**LOWER HEYFORD PC'S RESPONSE TO THE HEYFORD PARK MASTERPLAN
REF: 18/00825/HYBRID**

WALKING AND CYCLING STRATEGY

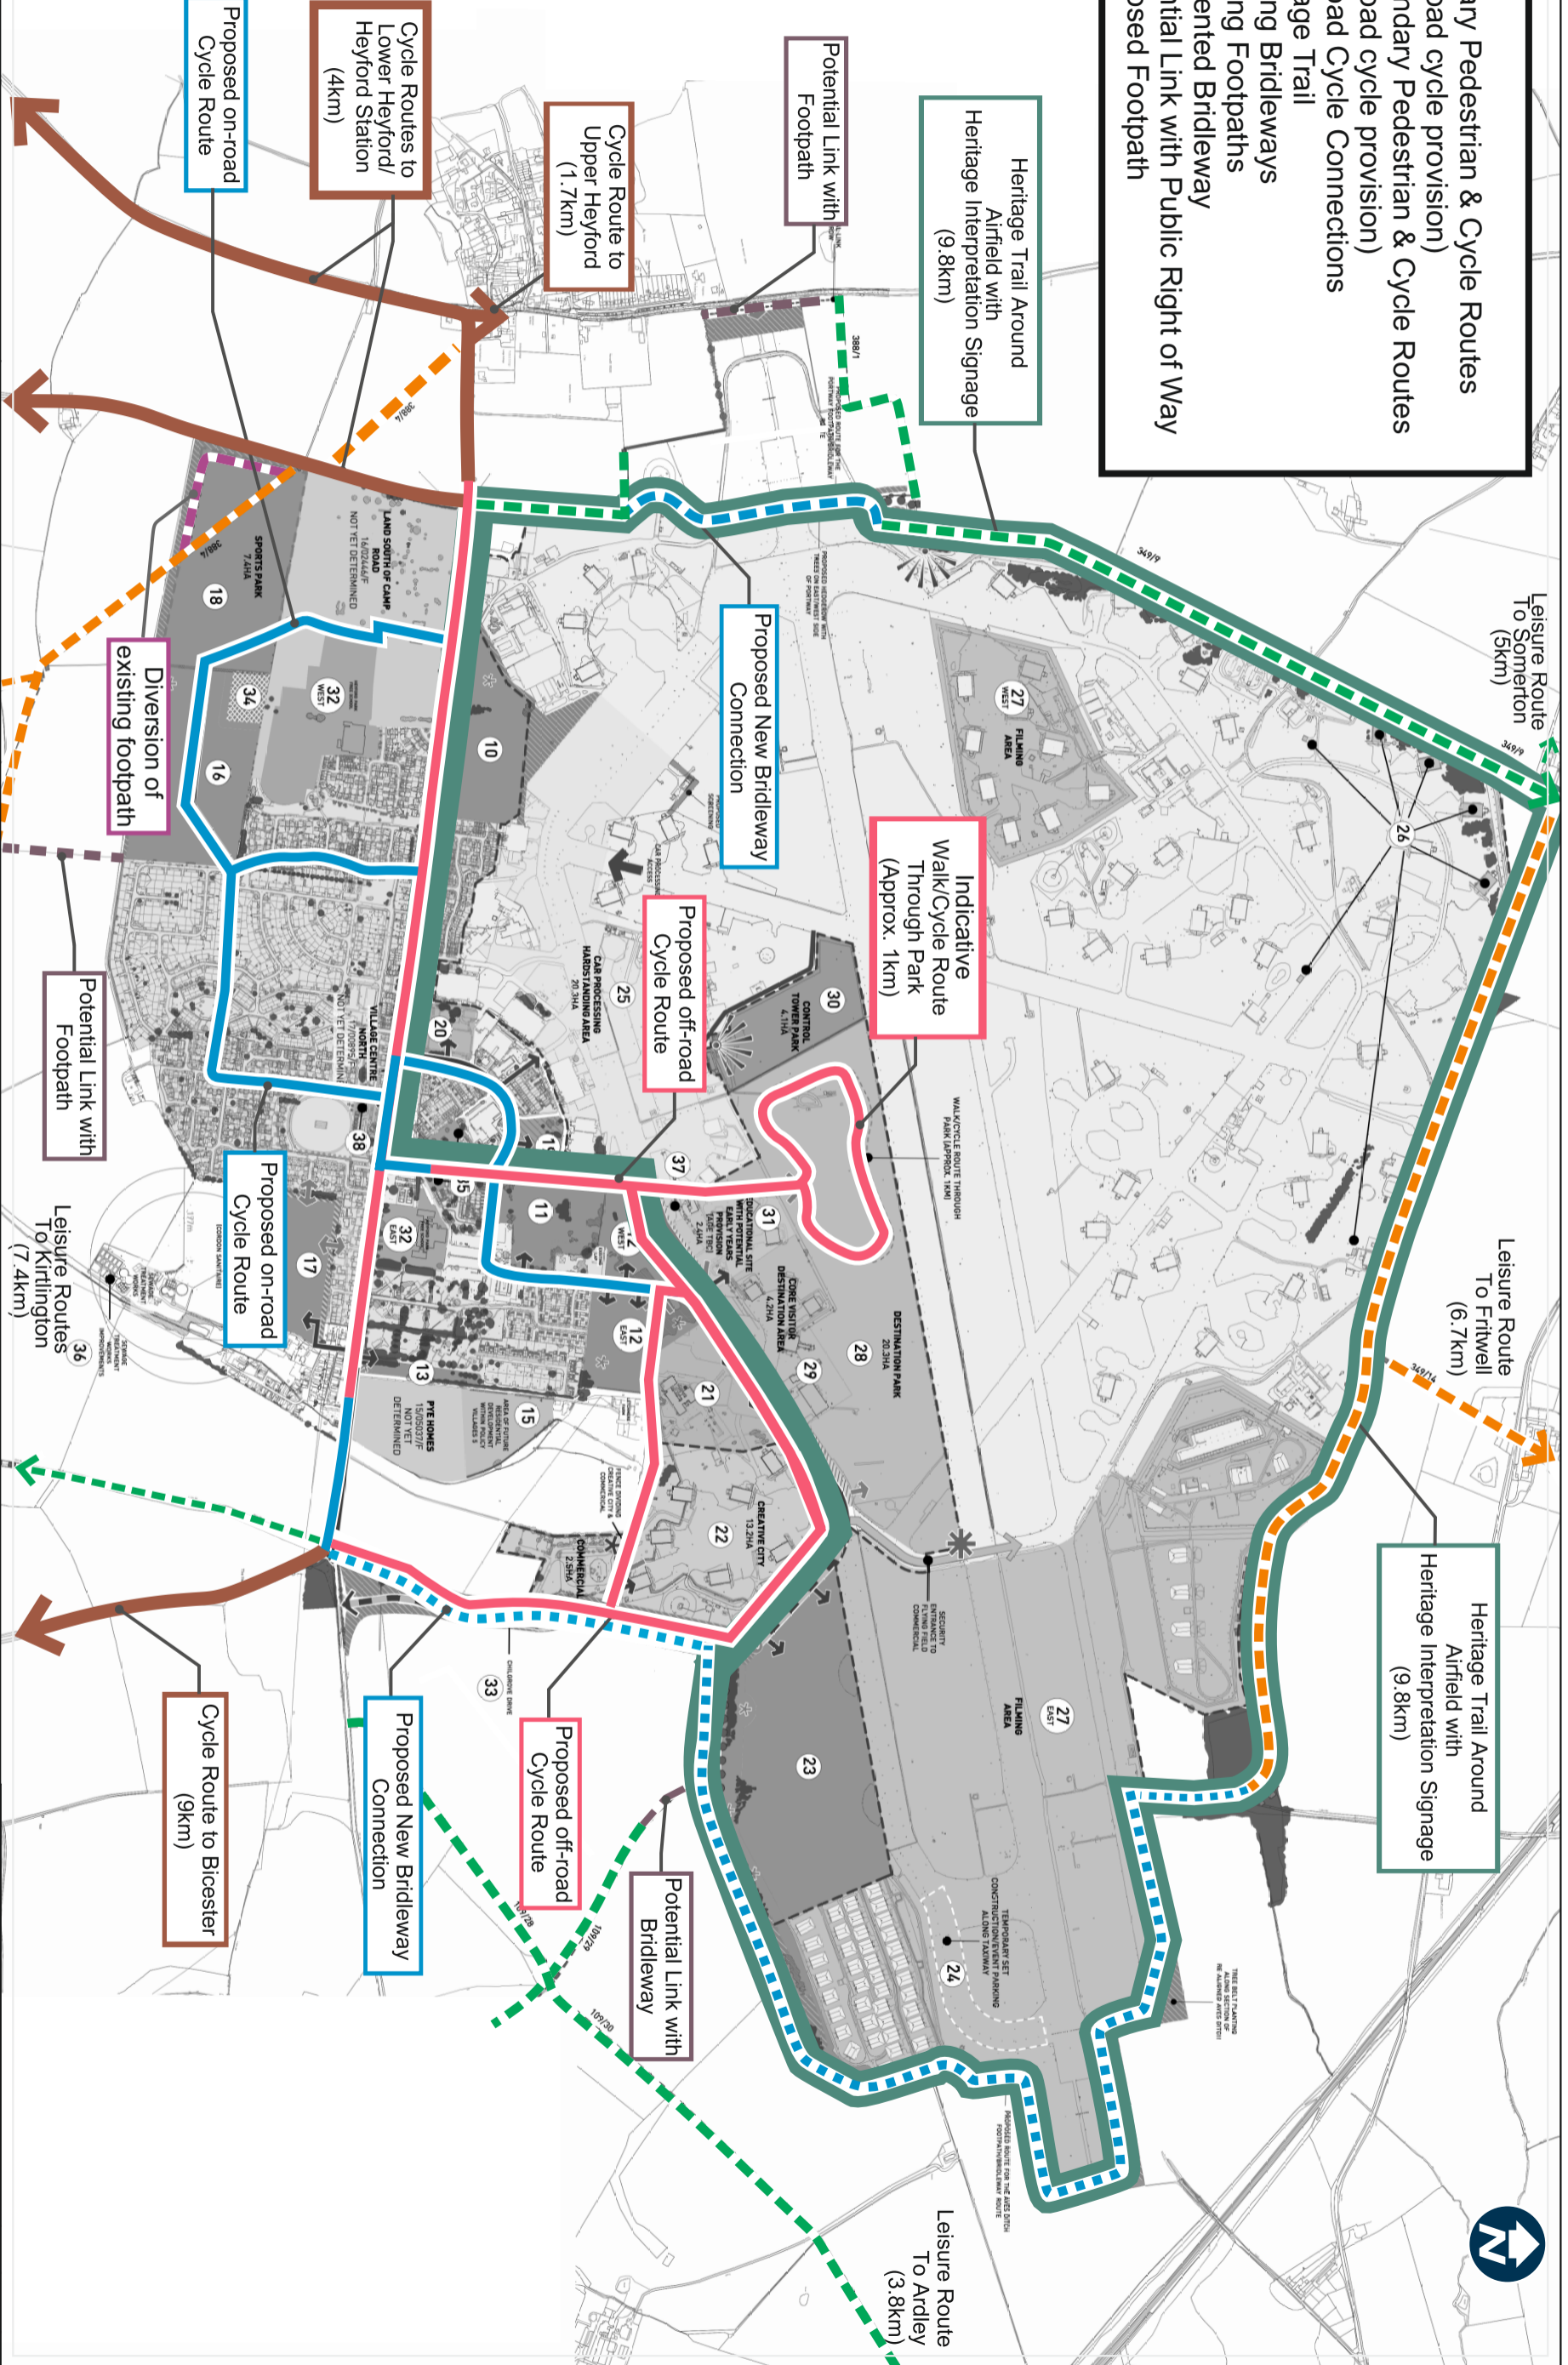
We see that the cycle path from Heyford Park to Heyford Station has been dropped in favour of a cycle path to Bicester. LHPC would like to see this reinstated. The station car park is near to capacity and we do not want to see an overspill of cars onto Station Road. It would encourage a more sustainable way to travel and it would enable local children to travel to the Heyford Park Free School independently and safely.
